Re: Structural Observation — 62 Angel Oak Drive, Bunnlevel, NC 28323

At your request, on February 3, 2022 we performed a review of the structural plan proposed by *Tarheel Basement Systems* for the foundation stabilization work at the Bunnlevel residence noted above. The structure is a conventionally framed, detached, single family residence with raised first floor framing over a pier/girder foundation system with perimeter masonry foundation walls (*see picture 1*).

Repair schematic

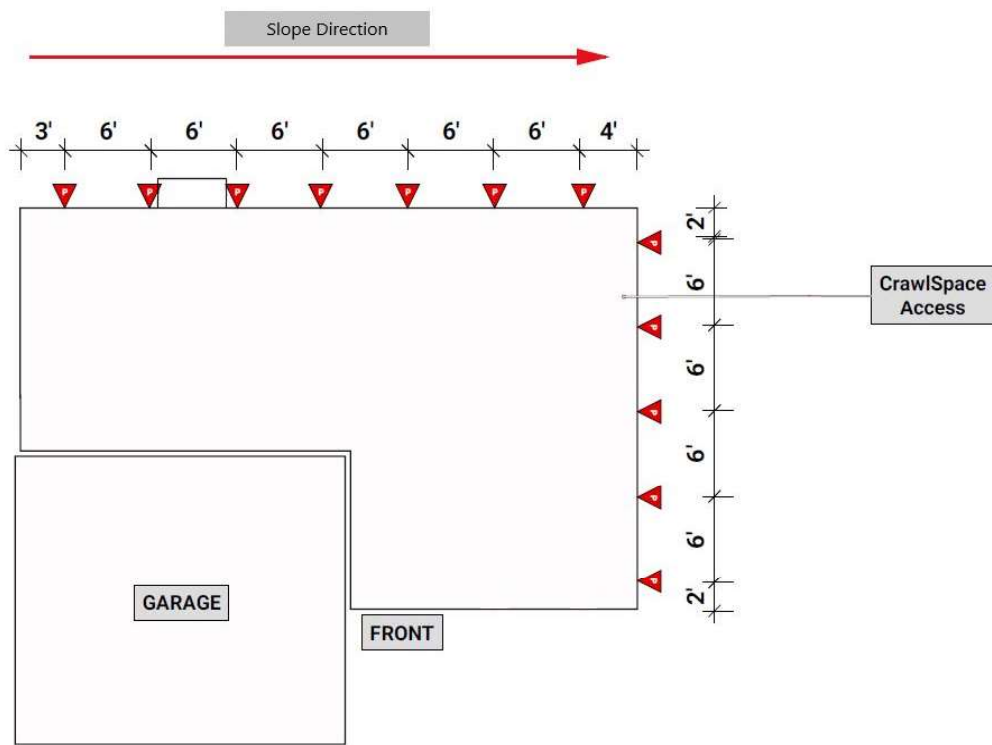
- To prevent future movement of the floor system, joists and the rim band along the back of the home should be shimmed using tight fit shim material to the tops of the knee wall top plates.
- To prevent future settlement of the back and right portions of the home, the proposed series of (12) galvanized steel helical piers or push piers may be installed.
  - Helical piers should be installed to a torque capable of developing 20 kips of axial load, or to refusal. Push piers should be driven until engagement of the structure with lift indicating adequate depth/frictional resistance along the shafts of the piers
  - The contractor should locate and avoid utilities prior to work

- Avoid installing piers under windows and doors
- Install piers at approximately 6' on center and at the approximate locations shown in the attached repair schematic.
